Recommendation Report for Planning Permission for Works or Extension to a Dwelling

REF NO: LU/275/20/HH

LOCATION: 6 Genoa Close
Littlehampton
BN17 6SE

PROPOSAL: Two storey side/rear extension and single storey front extension

A :: Proposed First Floor Plan
03 scale: 1:100

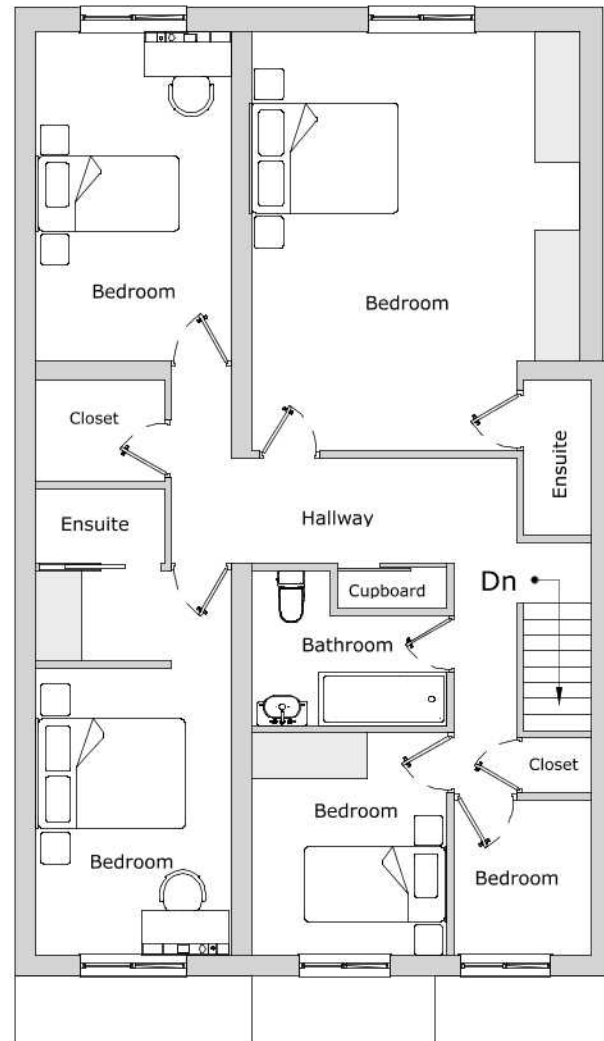
As a result of the scale of the proposal, and it abutting the western boundary of the application site, it will have an unneighbourly and overbearing impact upon the occupiers of the neighbouring property.

The extension also conflicts with the 45 degree rule at both ground and first floor and the overshadowing results in a loss of light to habitable rooms.

With regard to loss of privacy, all of the proposed openings are to the rear of the proposal and therefore there will be no undesirable overlooking of neighbouring gardens.

A	:: Proposed South Elevation
04	scale: 1:100

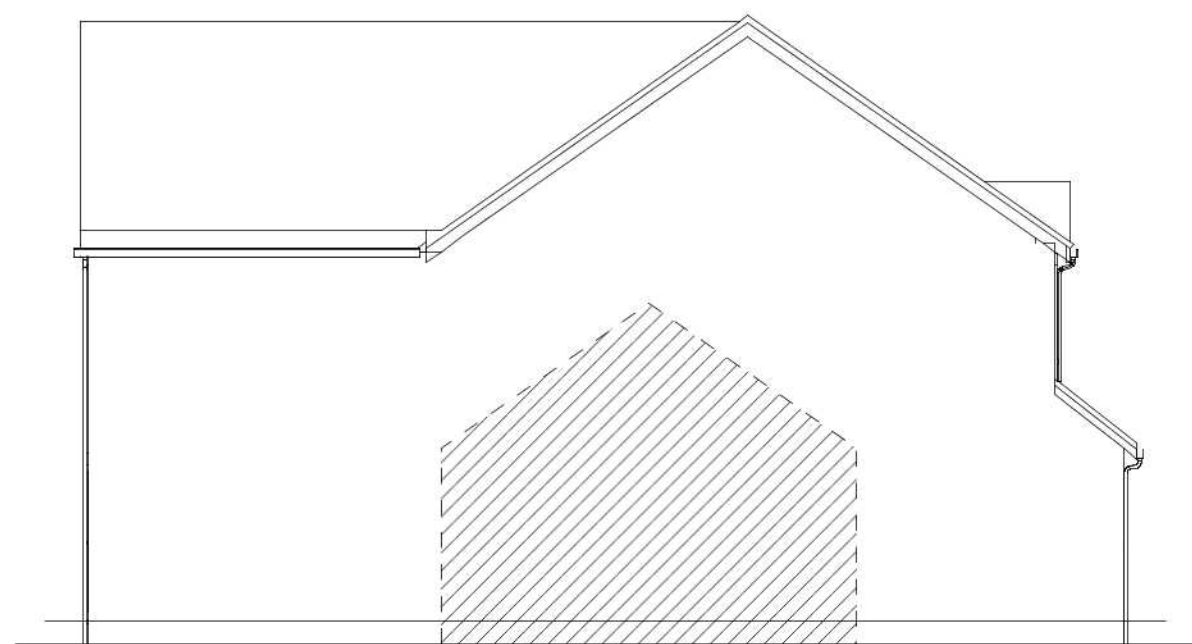
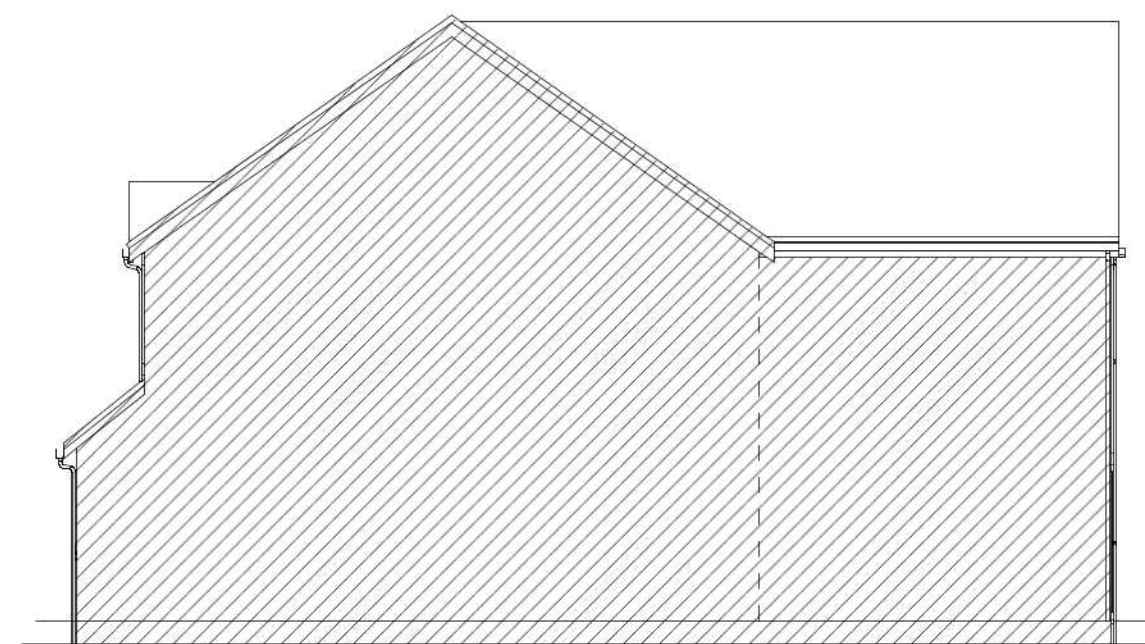
The maximum height of the proposal is 8.4m, with an eaves height of 5.2m. Whilst this is lower than the maximum height of the host dwelling itself by 0.1m, the proposed development is not considered to be subservient to the host dwelling as it will appear as a significant extension with a mass and design that is not visually integrated to the parent dwelling in conflict with policy D DM4(a) and (b) of the Arun Local Plan.

The proposed extension is at an eaves height of 5.2m when directly adjacent to the western boundary. At a projection length of 4.5m and at such close proximity this results in an unneighbourly impact upon the adjacent occupier, as it both overshadows and overbears this area of neighbouring amenity space.

The impact on the neighbour to the east is also considered to be domineering and unneighbourly due to the bulk of the structure on the boundary. It will have an unneighbourly effect overshadow the garage of the property it is considered unacceptably overbearing.
